Objection to Planning and Listed Building Consent Applications, Nos. 2018/92347 and 2018/92348

Partial demolition and change of use of ground and lower ground floors to offices and external alterations.

92 New North Road, Edgerton, Huddersfield

DRAWING DESCRIPTION
Car Park - Swept Paths
1 of 2

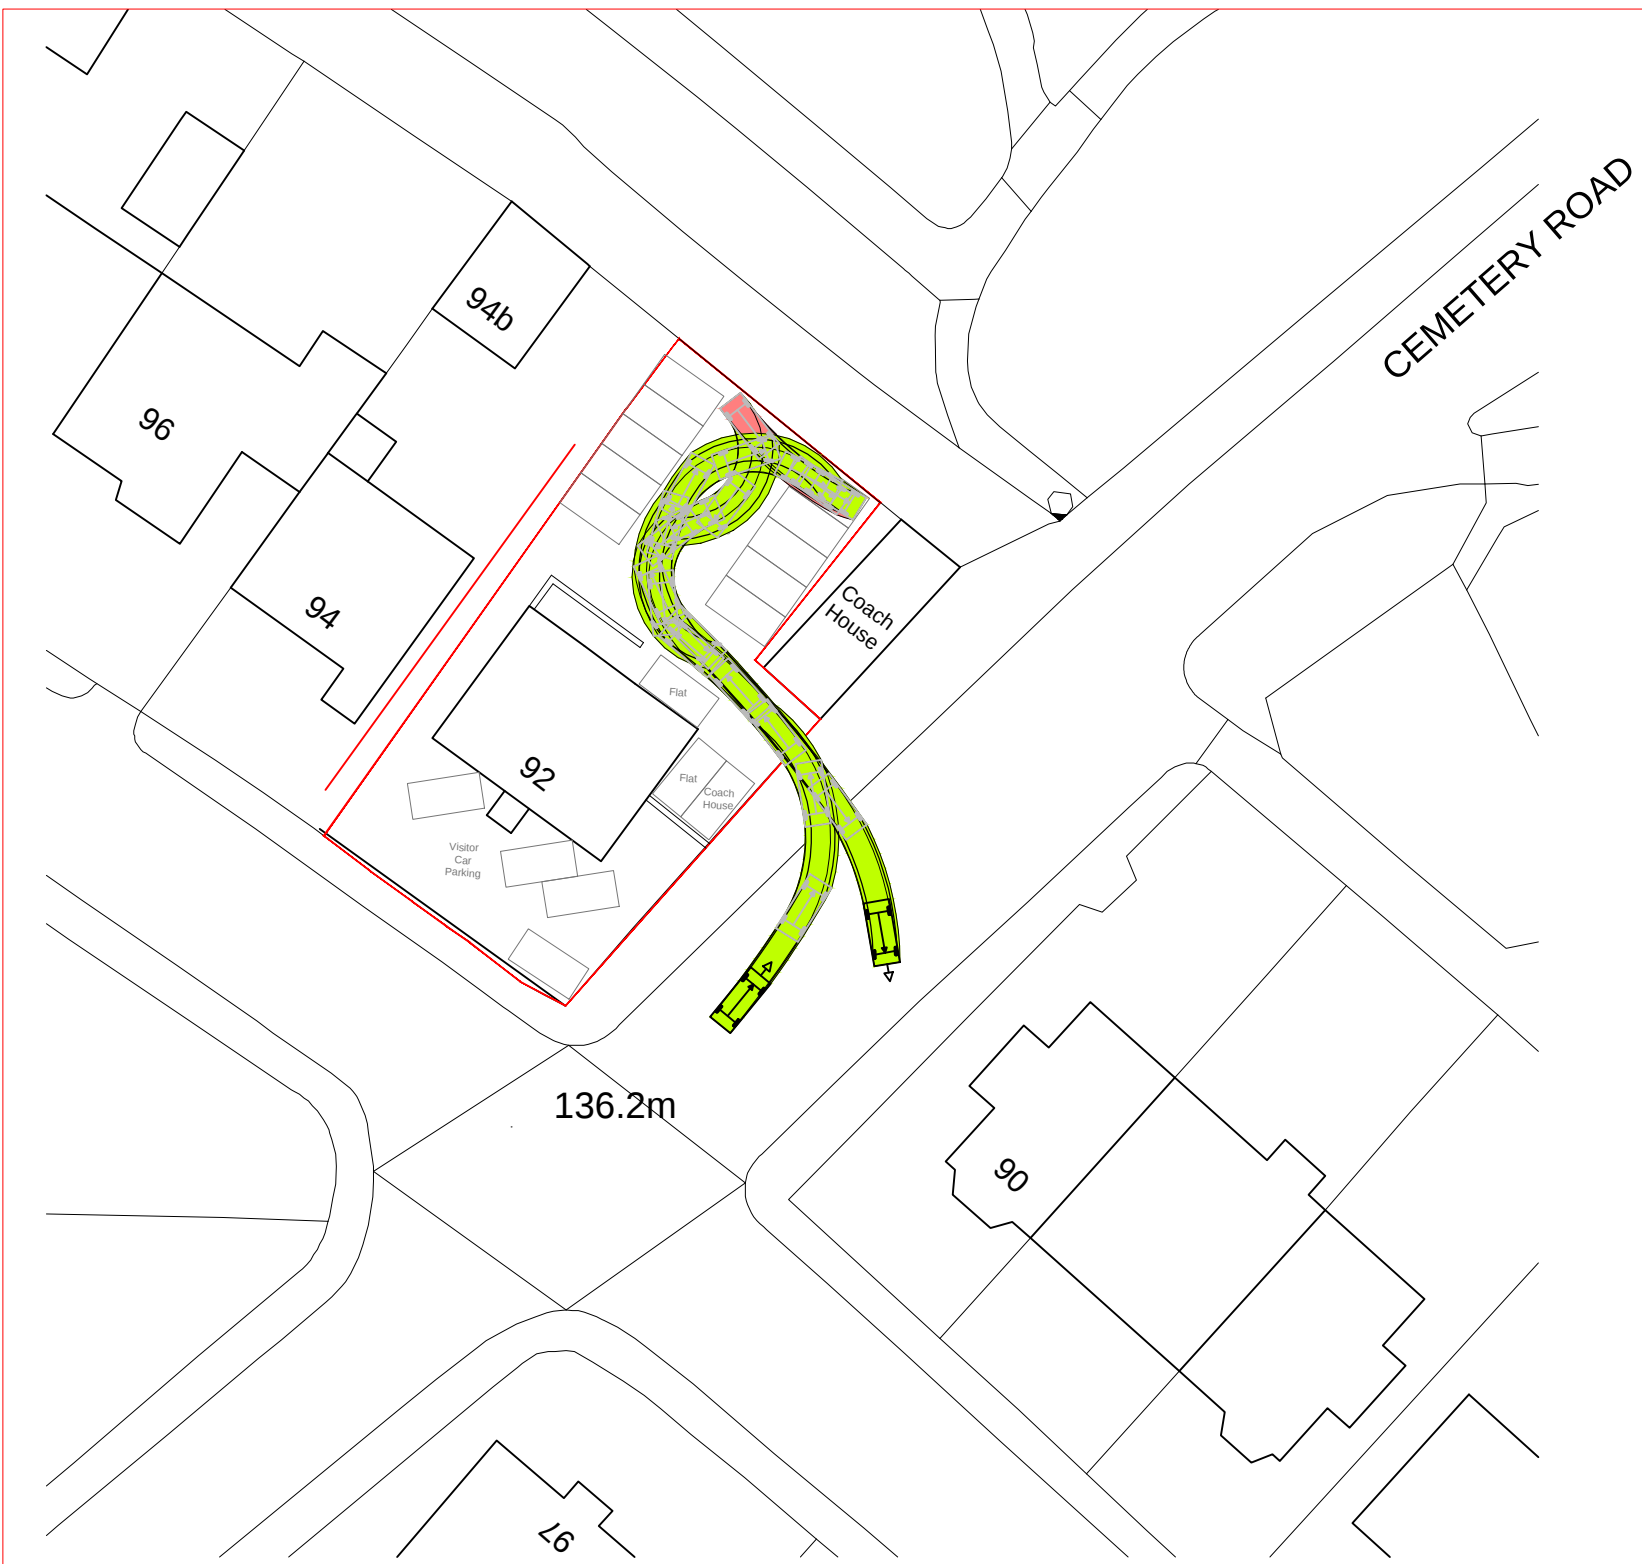
- First and foremost, the plans outlined for the carpark are not accurate. The spaces lined out for visitor parking will not be accessible as there is not ample space to pull a car into each spot. There is also not enough space for 7 car parking spaces where the garages lie, as the proposed area encroaches onto the land owned . There is also not enough space at the side of the building which is proposed for one flat space and one coach house space, only one car could fit in this area and that would be assuming the current waste disposal bins where to move (not shown on this plan) as they currently sit within this spot. The proposed parking layout, although difficult to scale accurately, appears to contain 2.5 x 5.0m parking spaces. Whilst spaces of this size were considered acceptable under the old West Yorkshire Design Guide and other Development Control publications, it is generally understood that such spaces are impractical for contemporary use given the higher proportion of large vehicles on the road today. You will assess this proposal against Draft Local Plan parking requirements, and find that whilst the number of spaces indicated appears satisfactory, the actual number of useable spaces is not.

- The plan does also not allow for manoeuvrability as the area is tighter than appears on the plans. Given that we share access through the courtyard, we would struggle to pull our vehicles past the cars parked centrally within the car park to leave the area. The reality of the situation is that sub-standard car parking provision leads to haphazard parking practices, and our access is likely to be impeded as a result.

- Access of the emergency services would be vitally impeded, as the fire and ambulance service would not have sufficient room to access our property. The car park is directly between our only entrance/exit point to our property and the courtyard entrance meaning there is insufficient room for these vehicles to pass.
